NC DEPARTMENT OF  
**HEALTH AND  
HUMAN SERVICES**

August 3, 2022

Re: Project No. HL-11358-MAS/TKM  
FID No. 120572  
Good Hope Hospital  
Psychiatric Bed Expansion  
Erwin (Harnett County)

The referenced project was inspected on July 27, 2022 by Mark Saulnier, Tony McQuage, Jerry Boyle and Luis Padilla. This project cannot be approved until the following deficiencies have been corrected:

1 FIRE ALARM - FLOOR PLAN
 1/8"=1'-0"

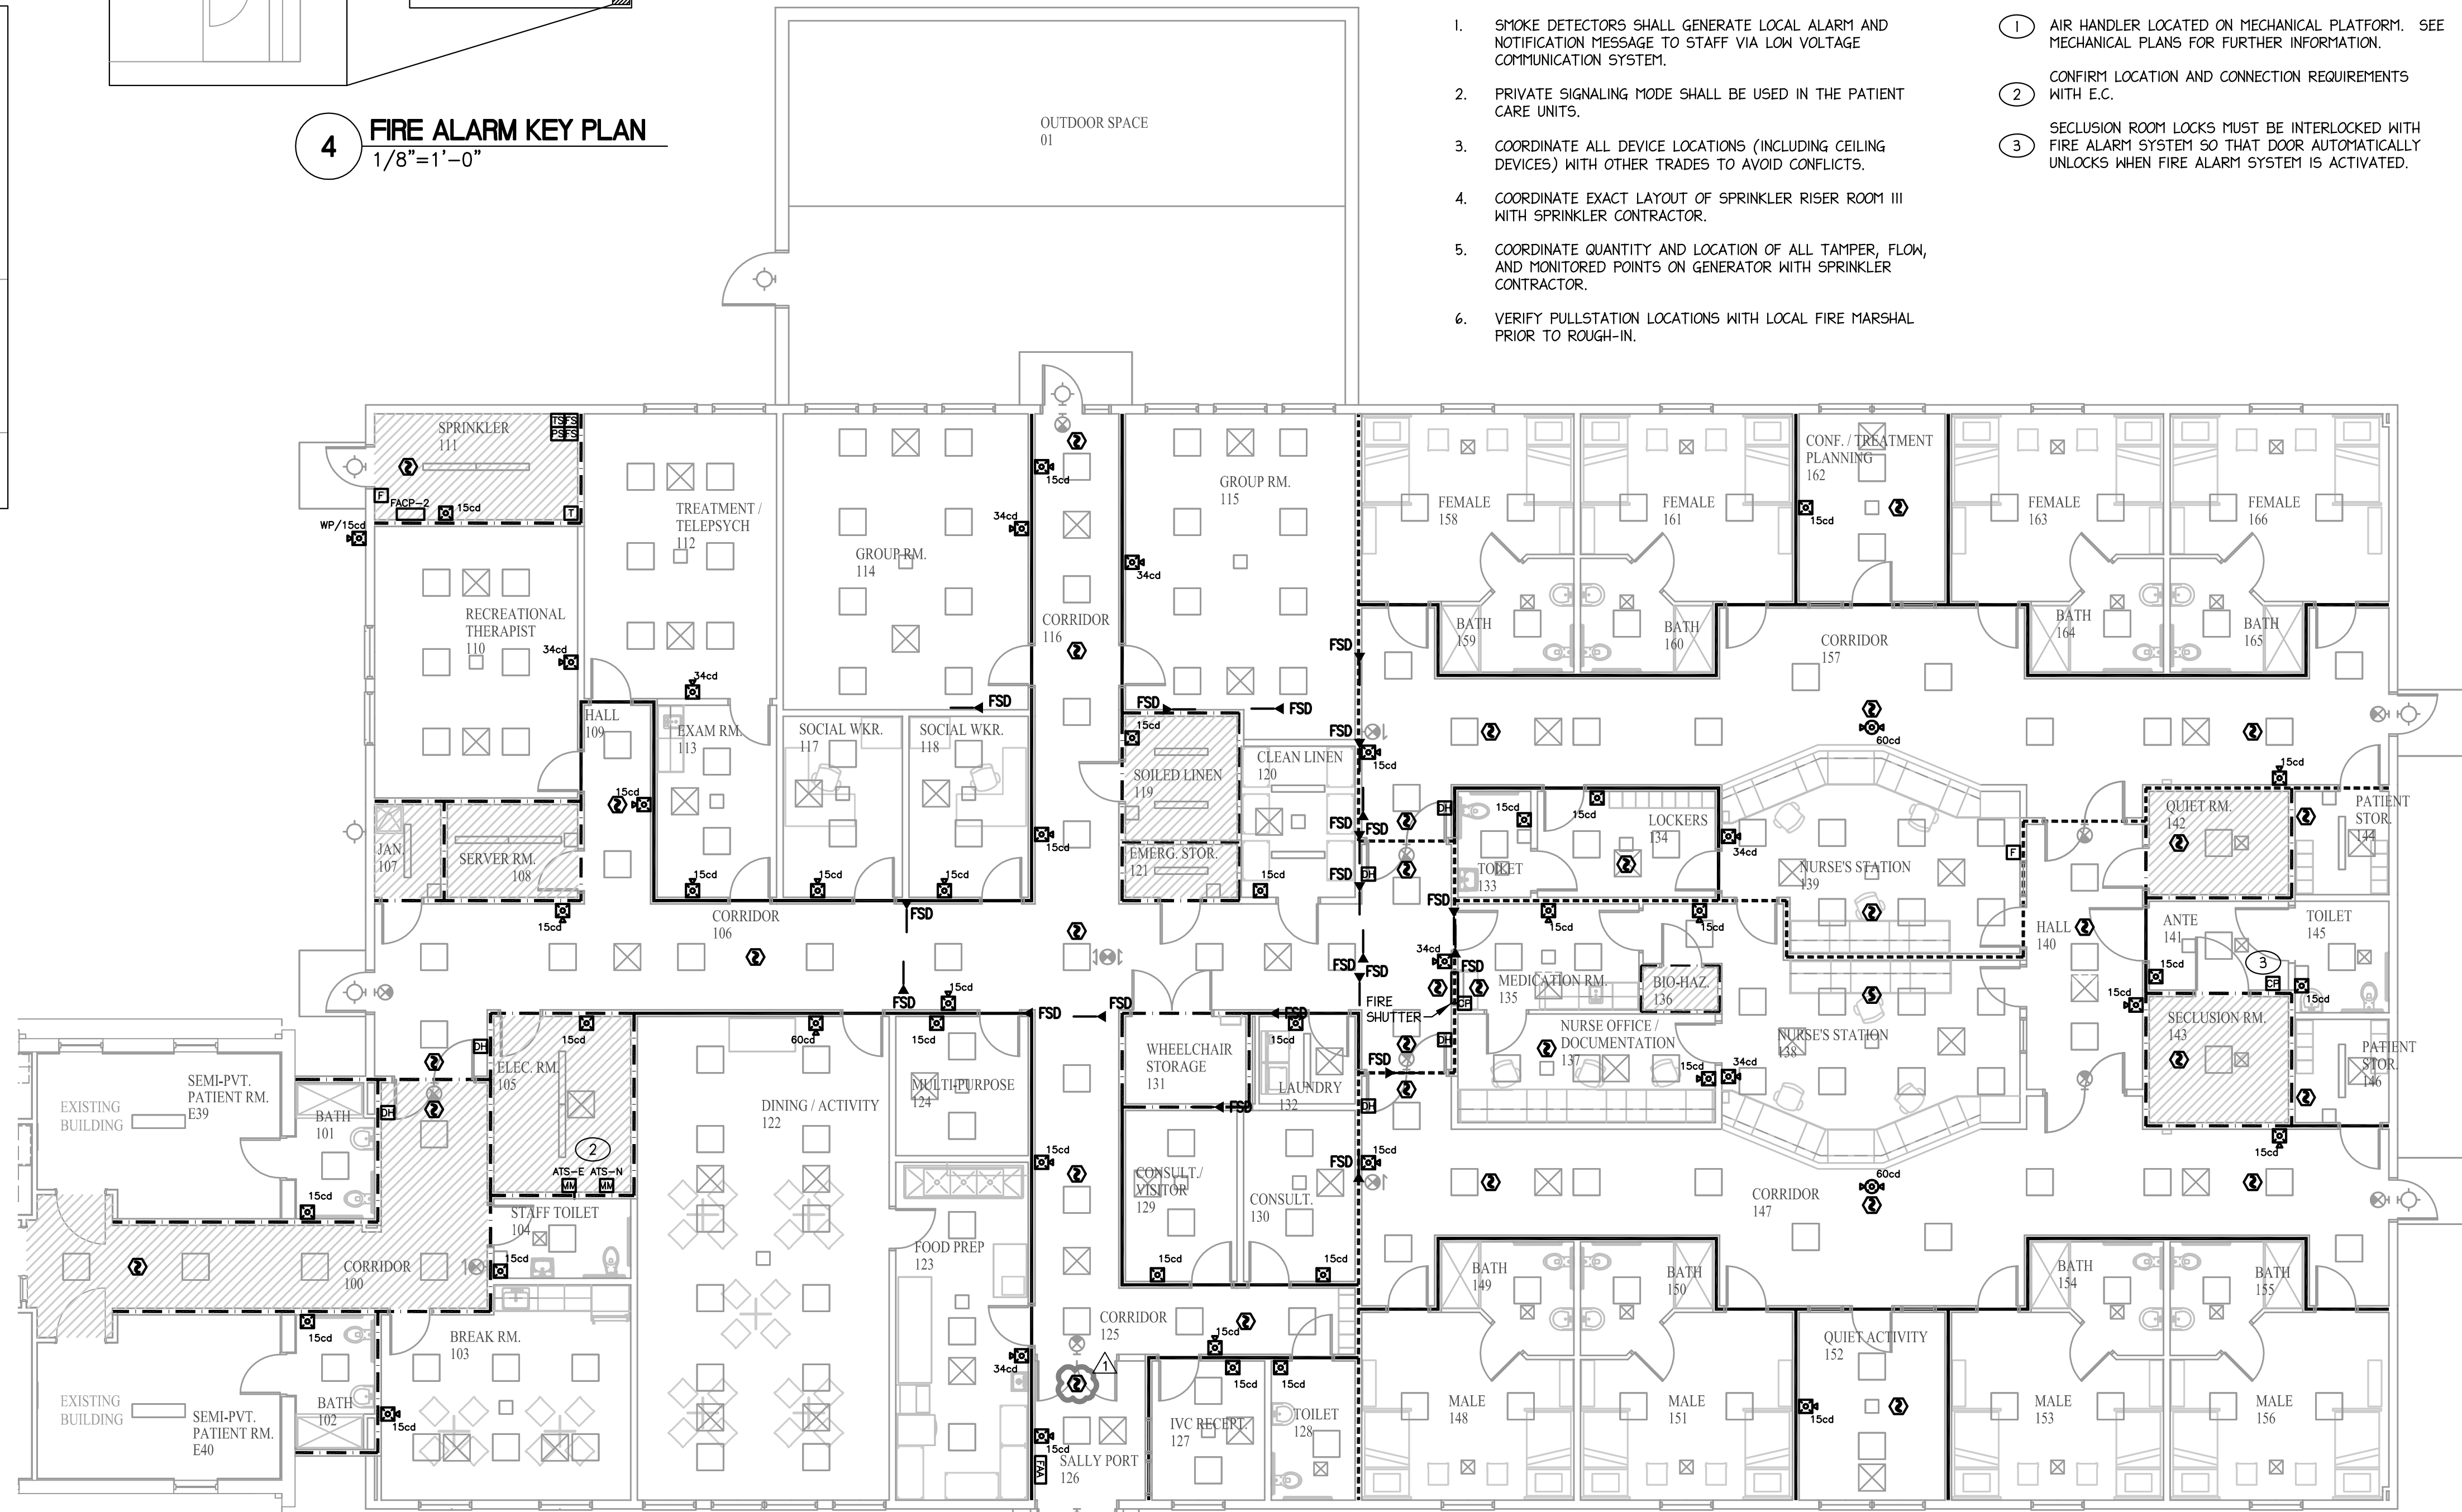
23. Install a smoke detector in Sally Port 126.
24. Multiple smoke detectors were located within (3) three feet of HVAC diffusers. Please check smoke detector placement throughout the facility. Smoke detectors shall not be installed within (3) feet of mechanical registers. [2013 NFPA 72, 29.8.3.4 (7)]

25. A smoke detector was installed in Seclusion Room 143. This smoke detector did not appear to be tamper and ligature-resistant type. Provide verification that detector is tamper and ligature resistant or replace. [2018 FGI, 2.5-7.2.2.7 (2)]

CONTRACT NAME:	GOOD HOPE HOSPITAL
CONTRACT WITH:	STE GENERAL CONTRACTORS
DESCRIPTION:	INFORMATION
SYSTEM DESIGN DATA	
CONTRACT NO.:	20K533
DRAWN BY:	M.FORD
DRAWING NO.:	FP 1 of 3

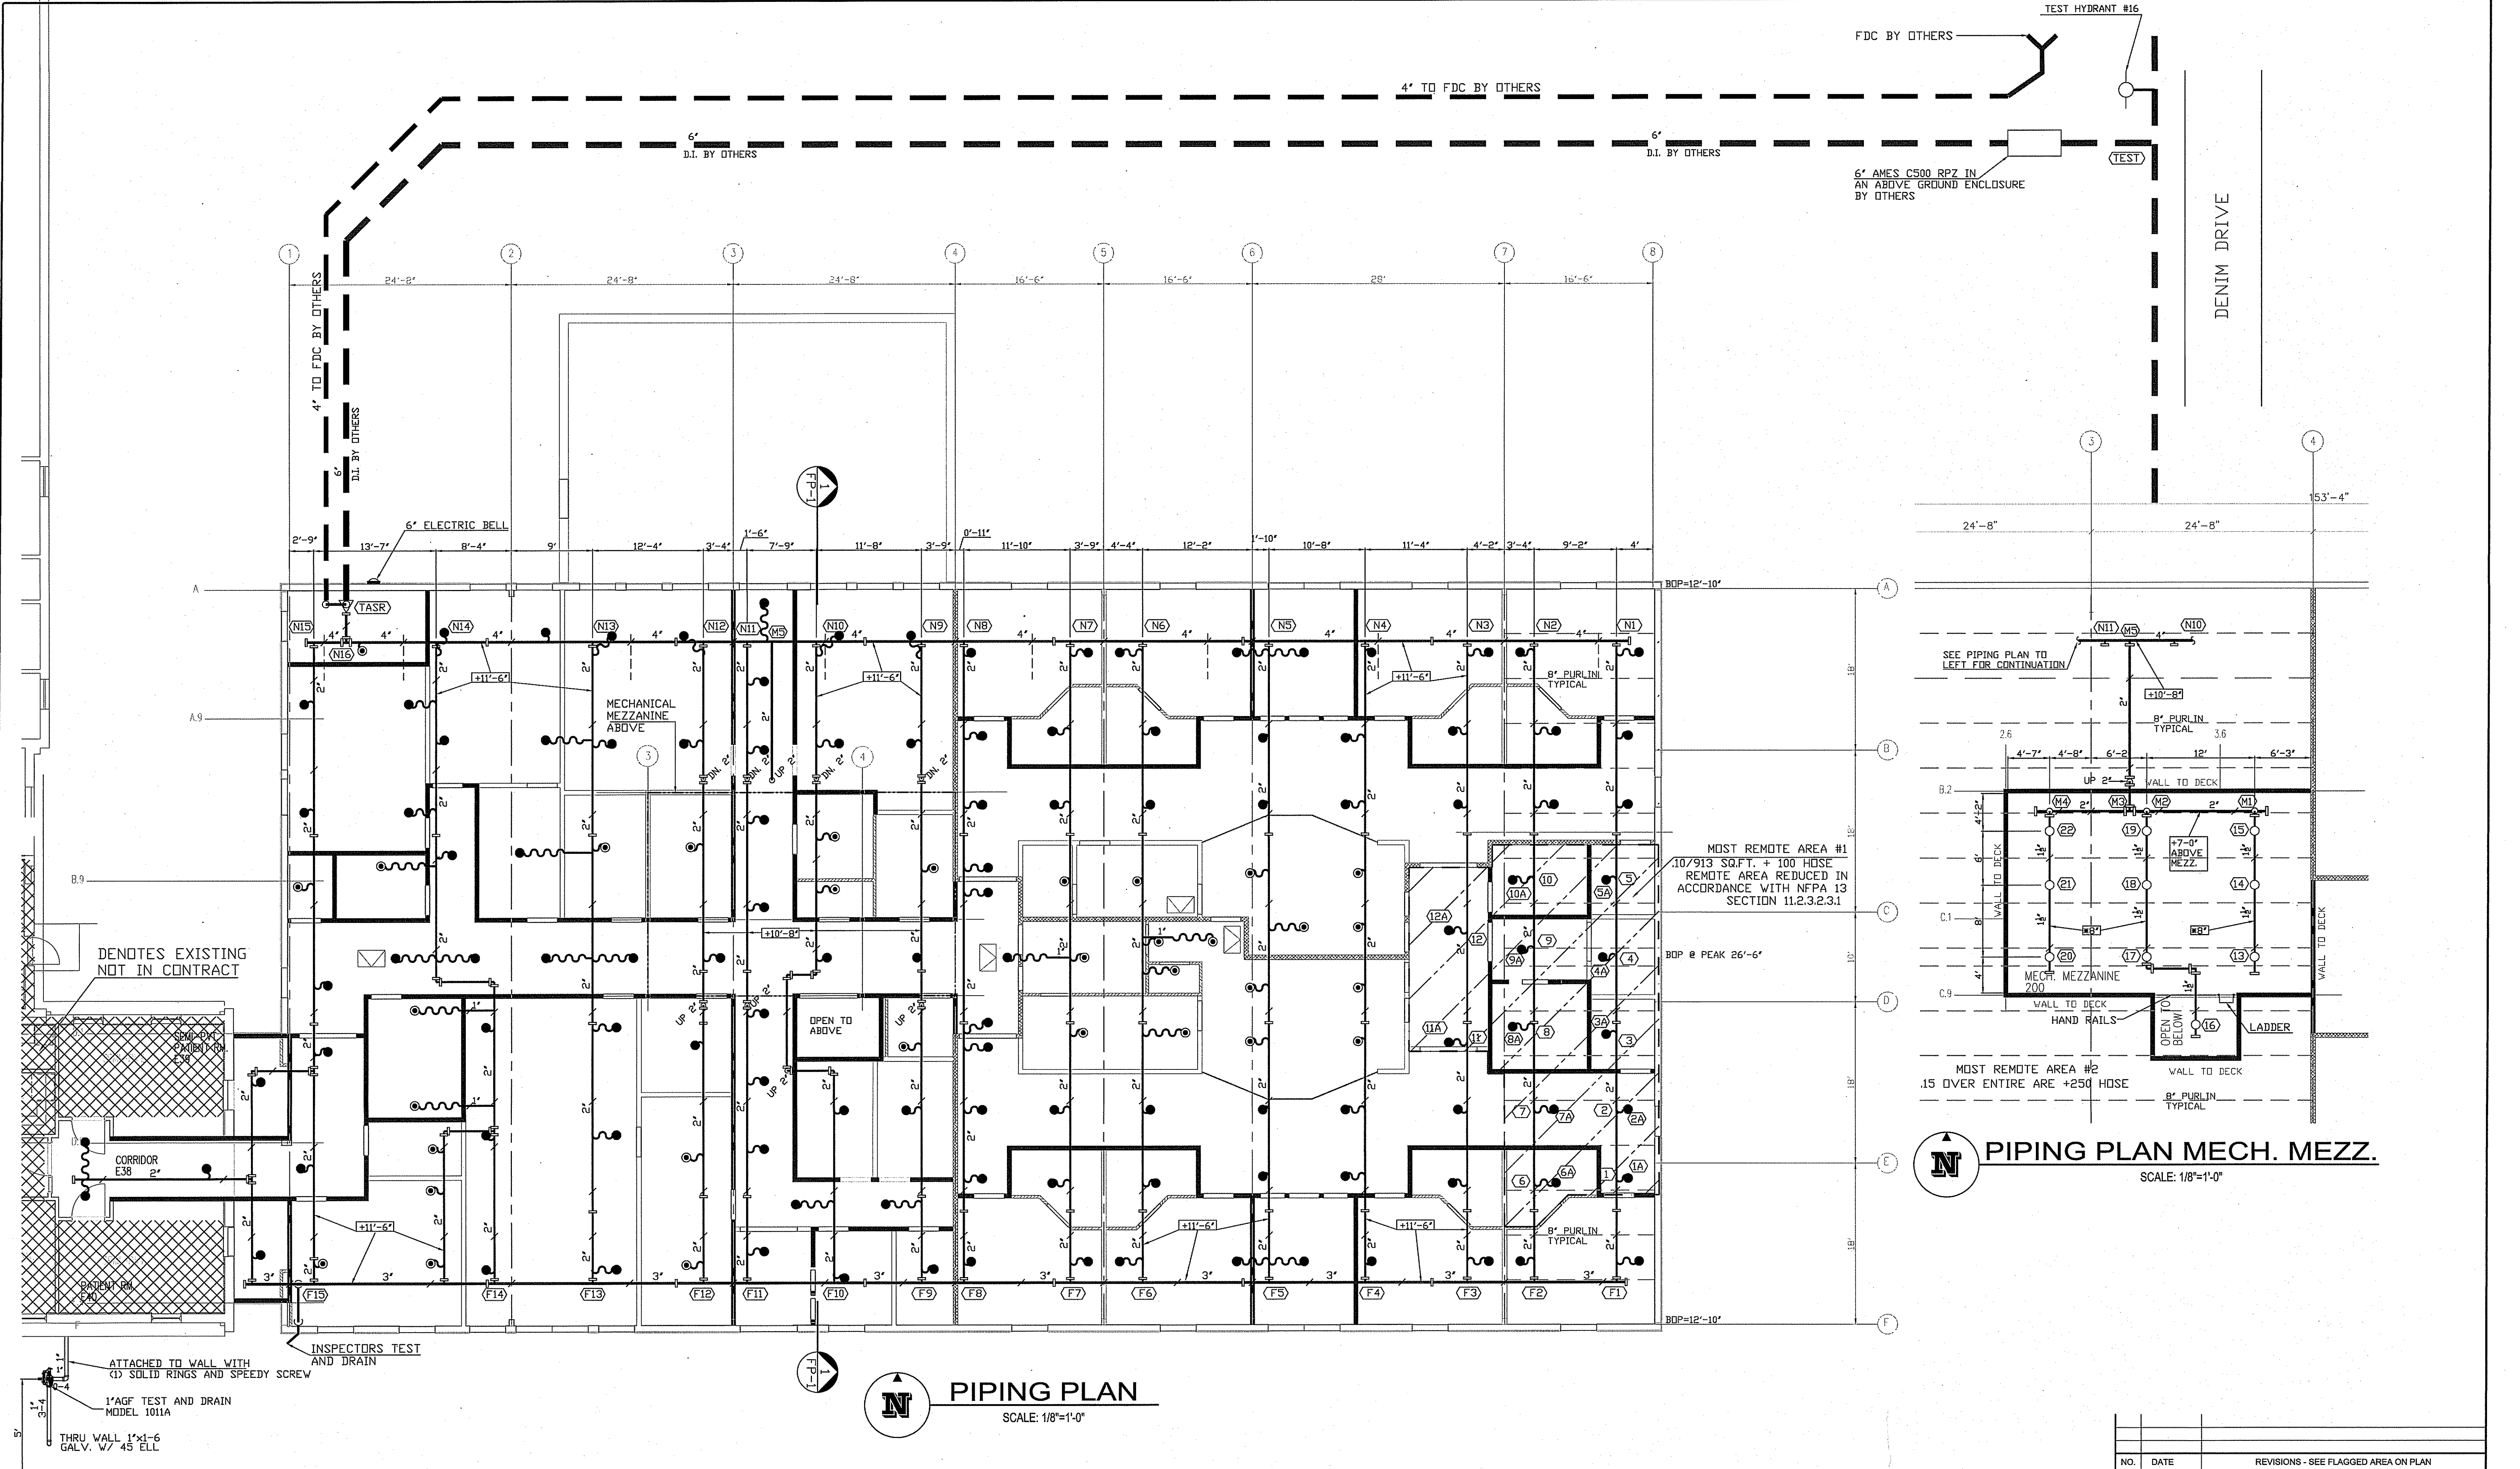
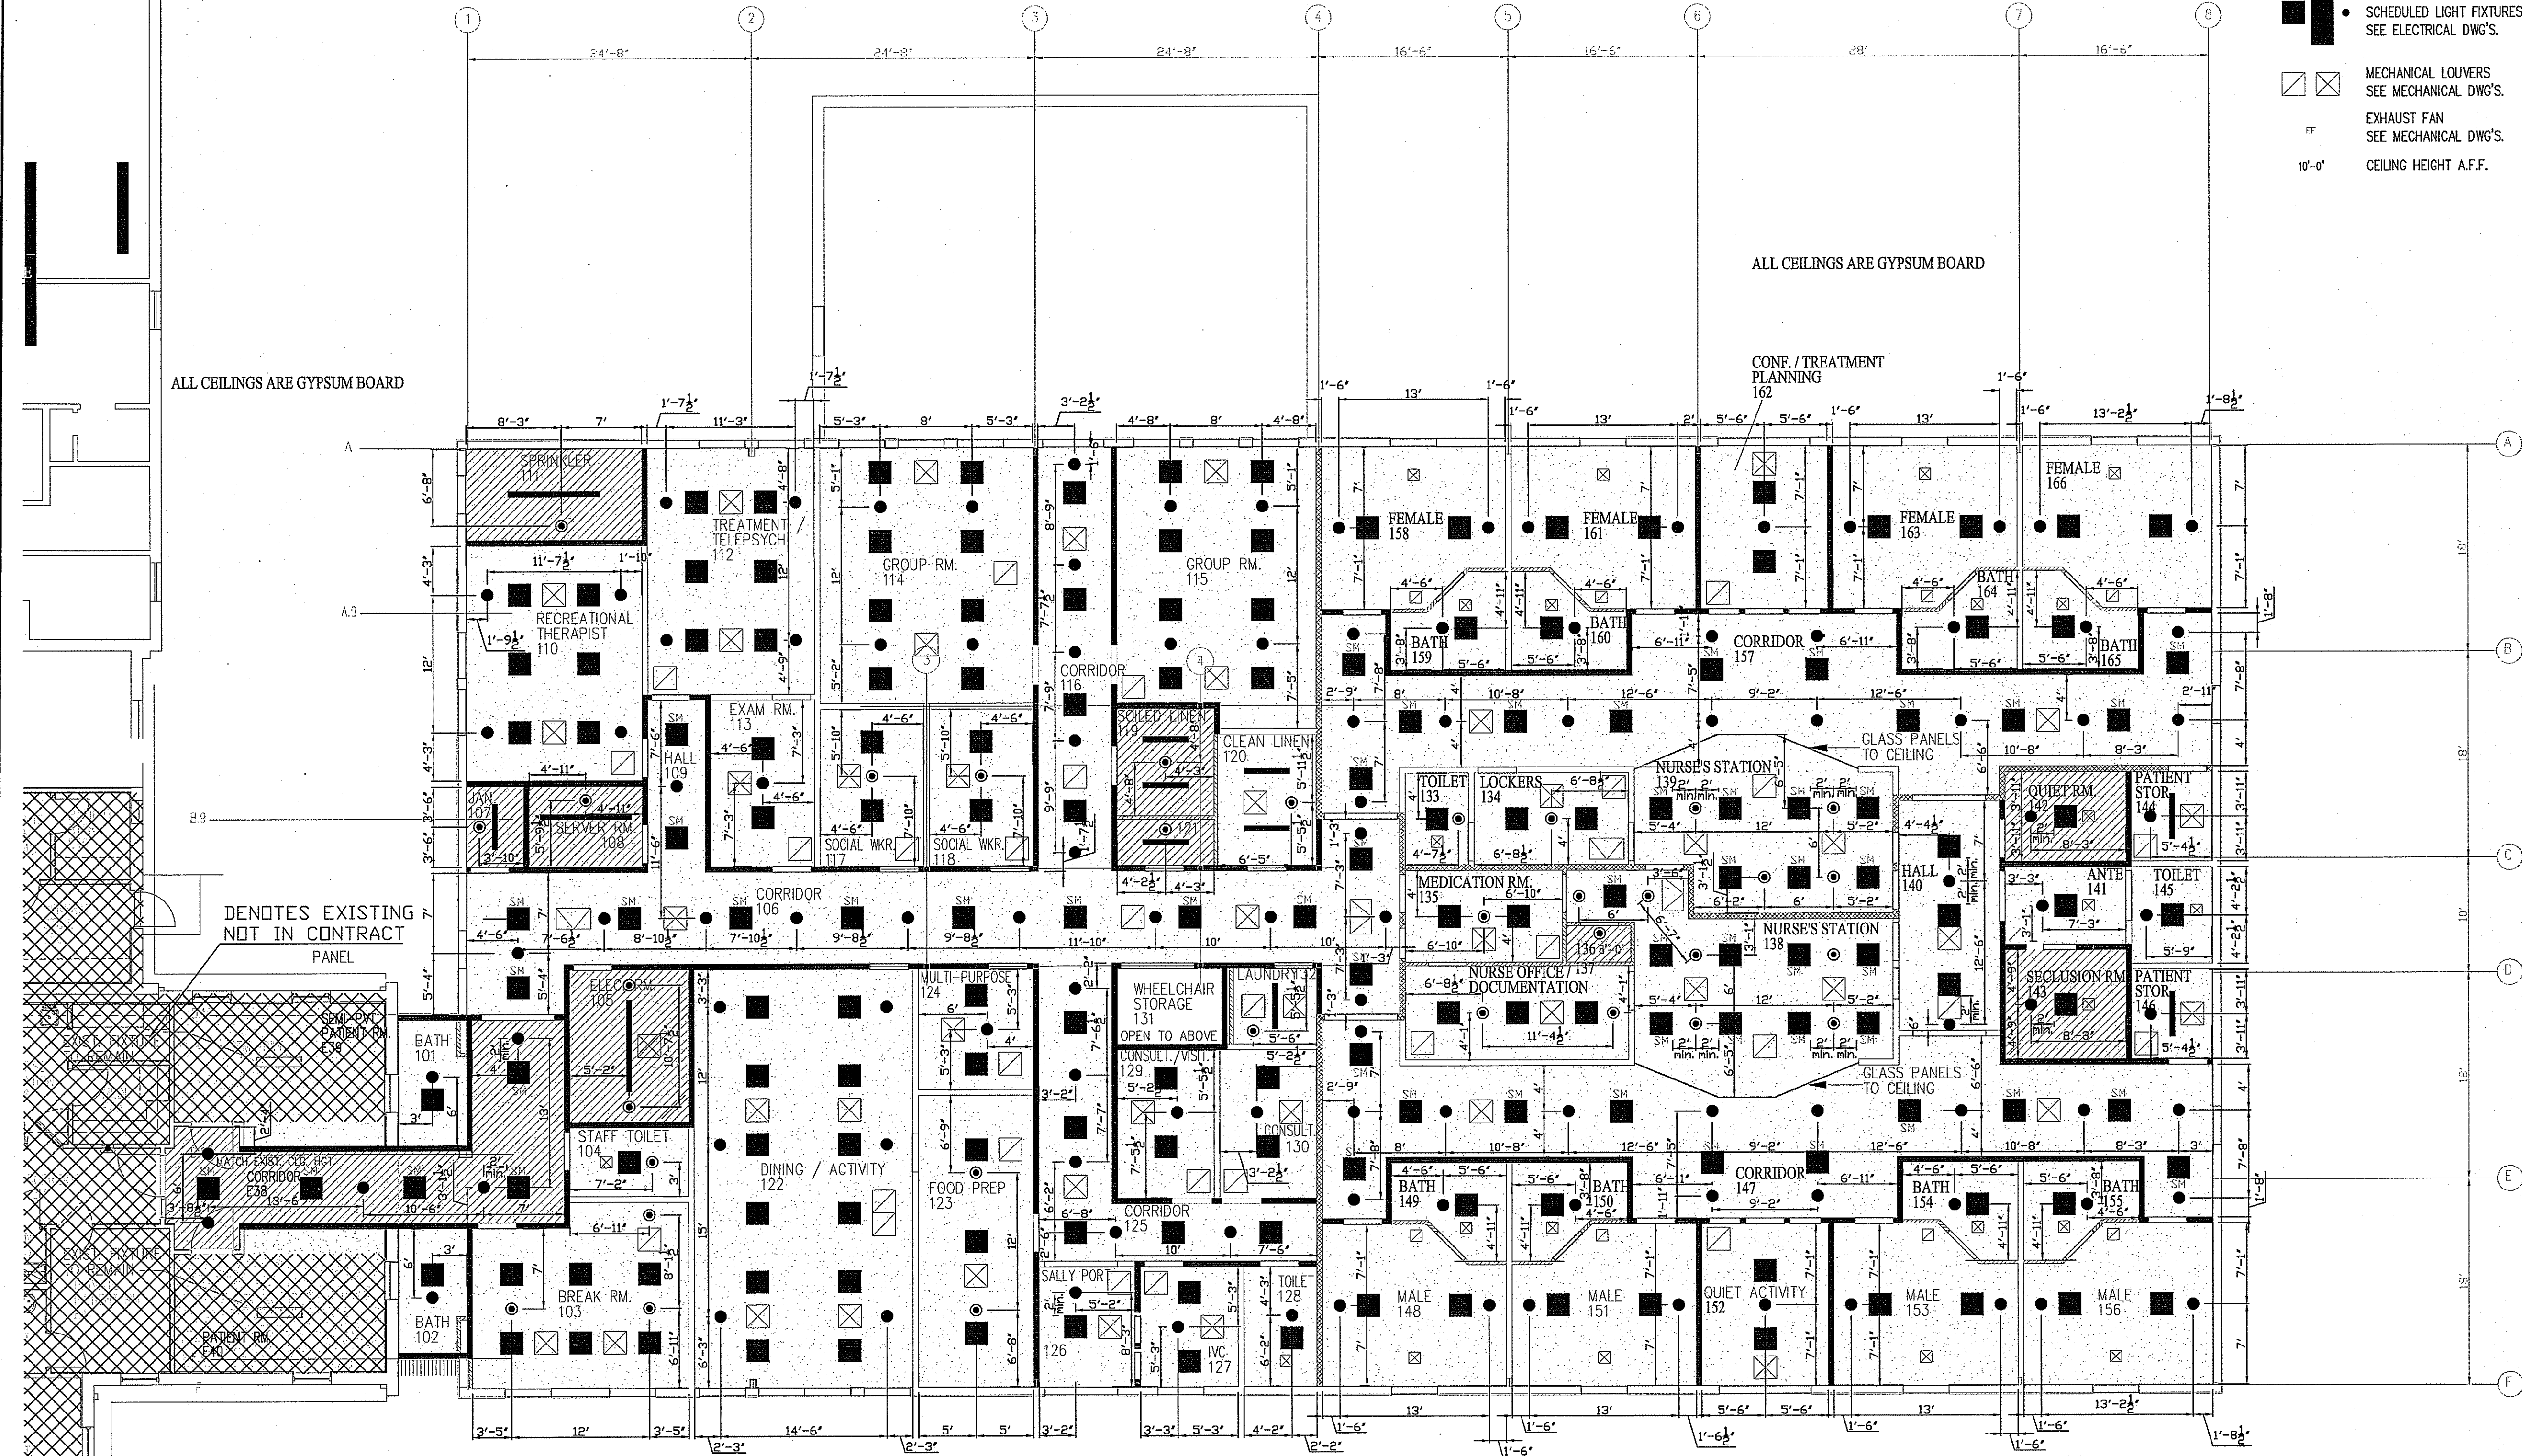
26. One pendant fire sprinkler head in Electrical Room 105 was obstructed by a conduit secured to the ceiling. Either the fire sprinkler head should be moved or electrical conduit. [2013 NFPA 13, 8.6.5.2.1.3(A)]

27. In patient areas, fire sprinkler heads shall be tamper and ligature-resistant type. [2018 FGI, 2.5-7.2.2.7 (1) (2)] Concealed pendant heads were installed in patient areas. Replace heads in patient areas with tamper and ligature-resistant type.
